Department of Primary Industries

OUT17/1220

Newcastle Inner City Bypass (SSI 6888) Comment on the Environmental Impact Statement

Figure 4-1

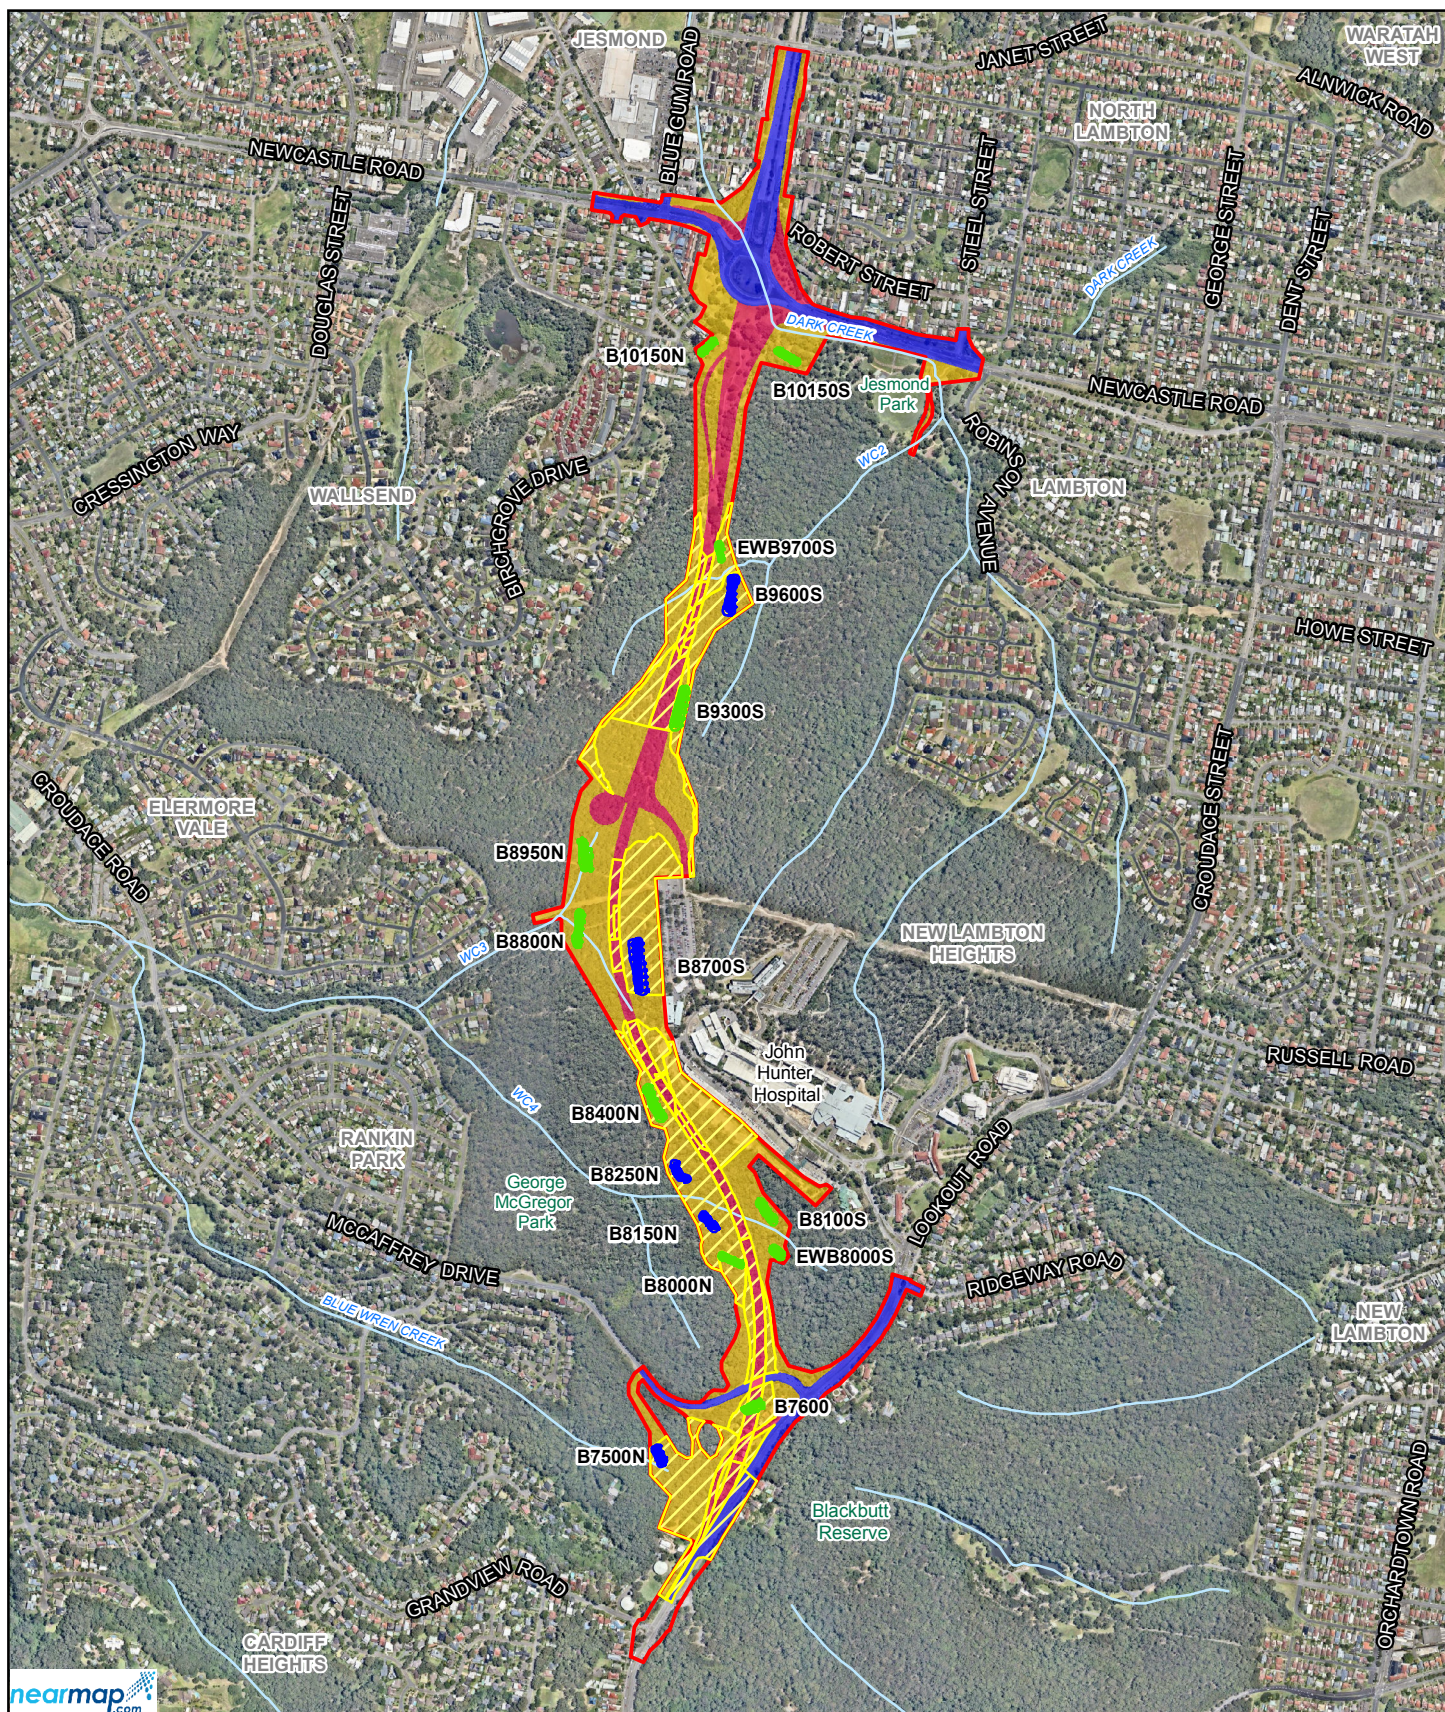
- The EIS indicated the potential for upstream migration of an existing gully head located downstream of the proposed bridge over watercourse 2. The proponent should give further consideration of the need to stabilise this site to mitigate future risk to road infrastructure and ongoing sedimentation in the watercourse.

- The proponent should provide further detail regarding the reshaping of watercourse 2 and the cross-drainage culverts proposed for watercourses 3 and 4 during detailed design.
